From: [Connor Armi](#)
To: [Zach Torrance-Smith](#)
Cc: [Guy Moura](#); [Hanson, Sydney \(DAHP\)](#)
Subject: Re: SD-24-00001 & CU-24-00005 Red's Fly Shop - Notice of Application
Date: Tuesday, June 25, 2024 3:03:32 PM

This consult is in reference to a SD-24-00001 & CU-24-00005 Red's Fly Shop. This undertaking involves ground disturbance to add an additional 1400ft² (Approx.) in floor space to the first floor of the existing building.

SUBJECT: WDFW COMMENTS ON SD-24-00001/CU-24-00005 RED'S FLY SHOP

TO: All Staff
FROM: Public Works Plan Review Team
DATE: July 1, 2024
SUBJECT: SD-24-00001 & CU-24-00005 Red's Fly Shop

1 SITE PLAN
SCALE: 1" = 20'-0"

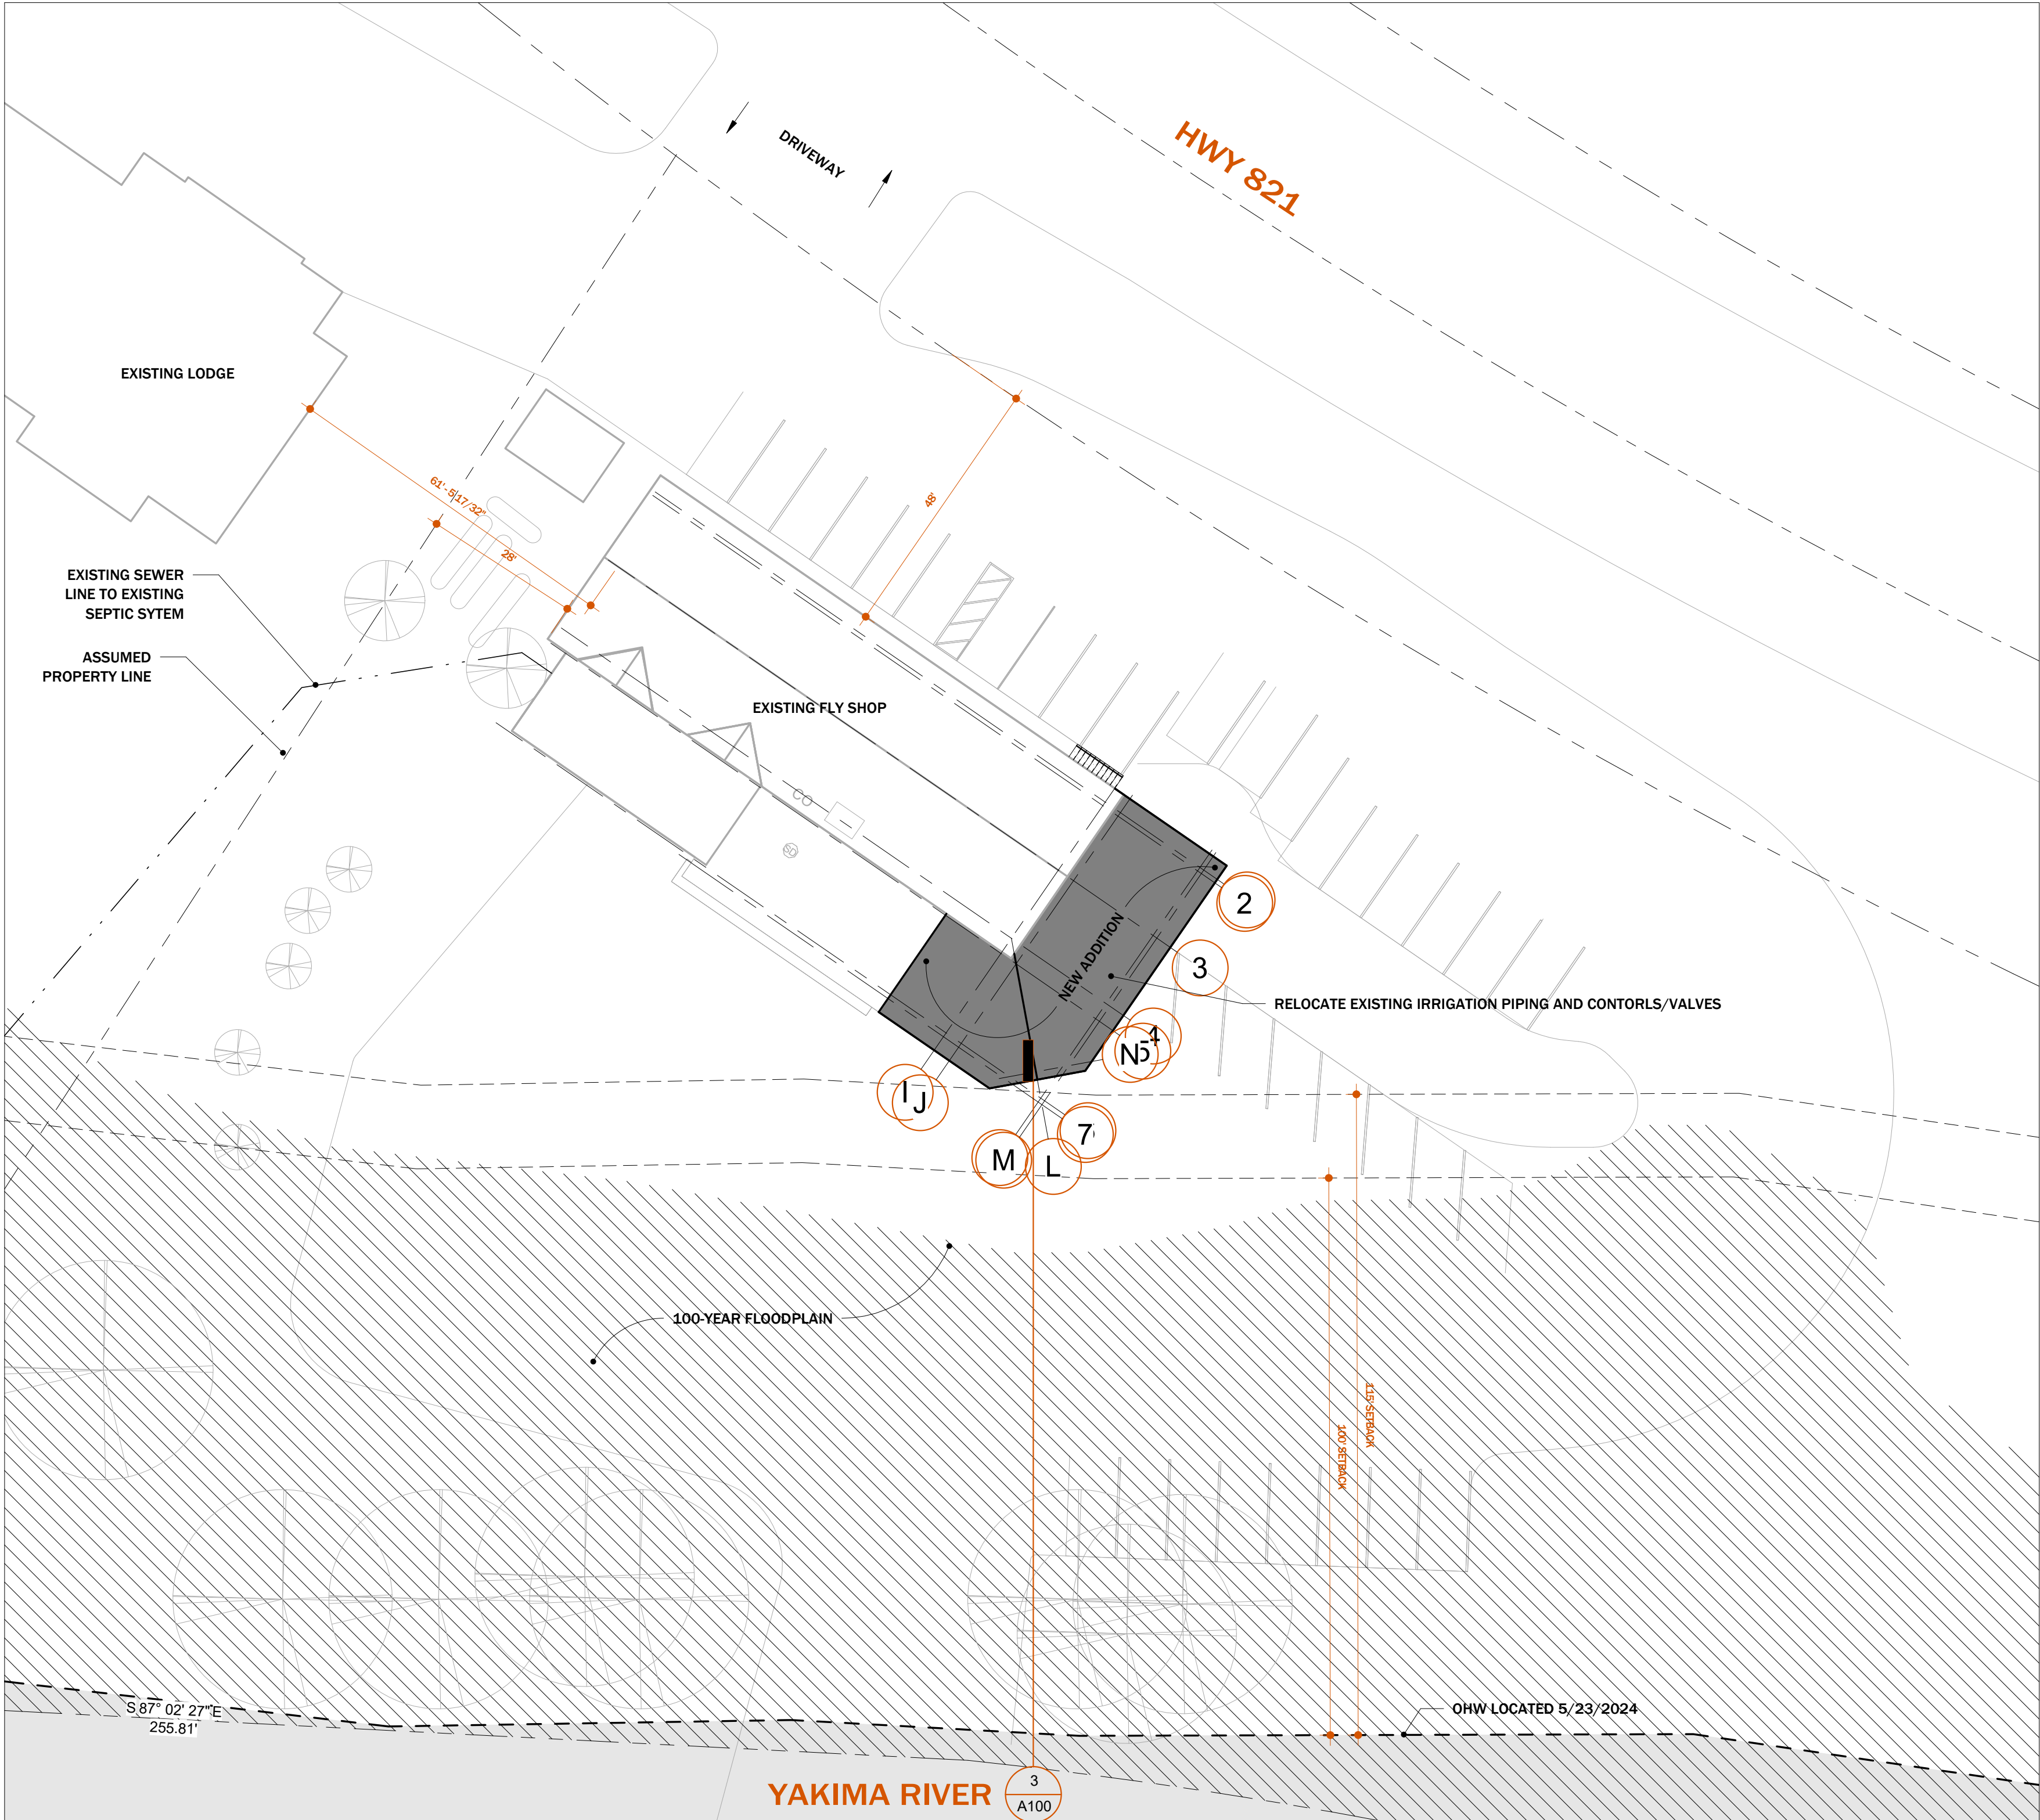
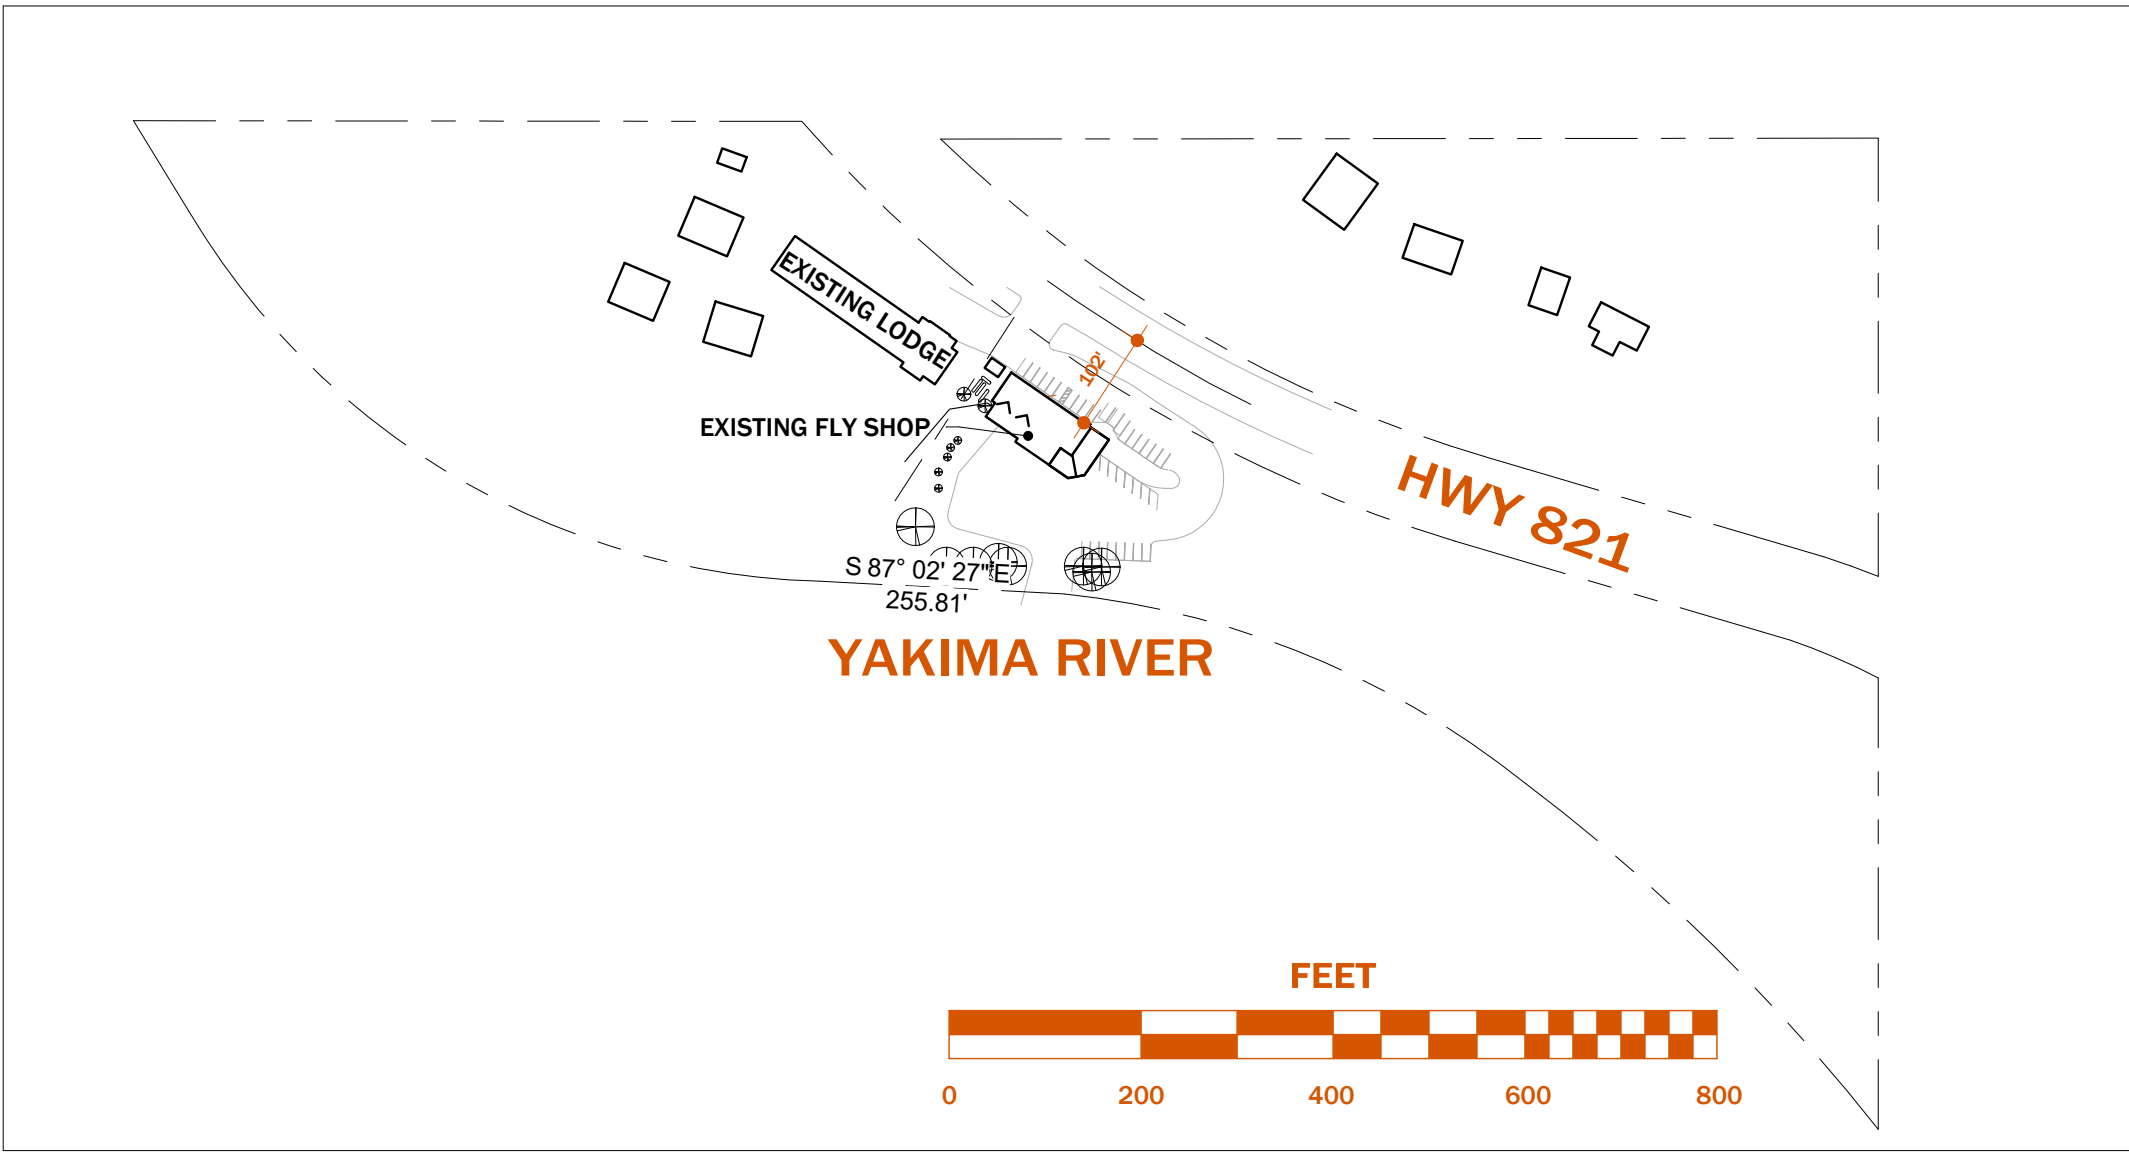
Because the project area falls within a BAC and there will be a temporary and long-term increased risk of runoff to the Yakima River and the fish life in it, **we recommend additional riparian plants along the Shoreline within the parcel in addition to BMPs during construction.** WDFW would welcome the opportunity to complete a site visit with the County and/or project proponents to identify areas where additional shoreline vegetation would benefit the river and be compatible with the overall uses on the property.

ACCESS	Existing access will be used. No additional access comments. (JS)
ENGINEERING	Except as exempted in KCC 14.05.060, no grading or filling upon a site involving more than one hundred (100) cubic yards shall be performed without a grading permit from the County Engineer or Public Works designee (KCC 14.05.050). An application for grading in excess of five hundred (500) cubic yards shall be accompanied by an engineered grading plan (KCC 14.05.080). (CP)
SURVEY	No survey provided, no comments (KH)
TRANSPORTATION CONCURRENCY	No transportation concurrency application is required for this project. (KAH)
FLOOD	<p>A portion of this property is within the 100-year floodplain. Since the proposed activity is outside the 100-year floodplain a floodplain development permit will not be required.</p> <p>If possible, any future development should also remain outside of the floodplain in order to reduce risk and avoid mandatory flood insurance purchase requirements. All activities within the floodplain must be permitted through the floodplain development permit process and follow the regulations within KCC 14.08.</p> <p>Please include the floodplain boundary on the site plan. (SC)</p>
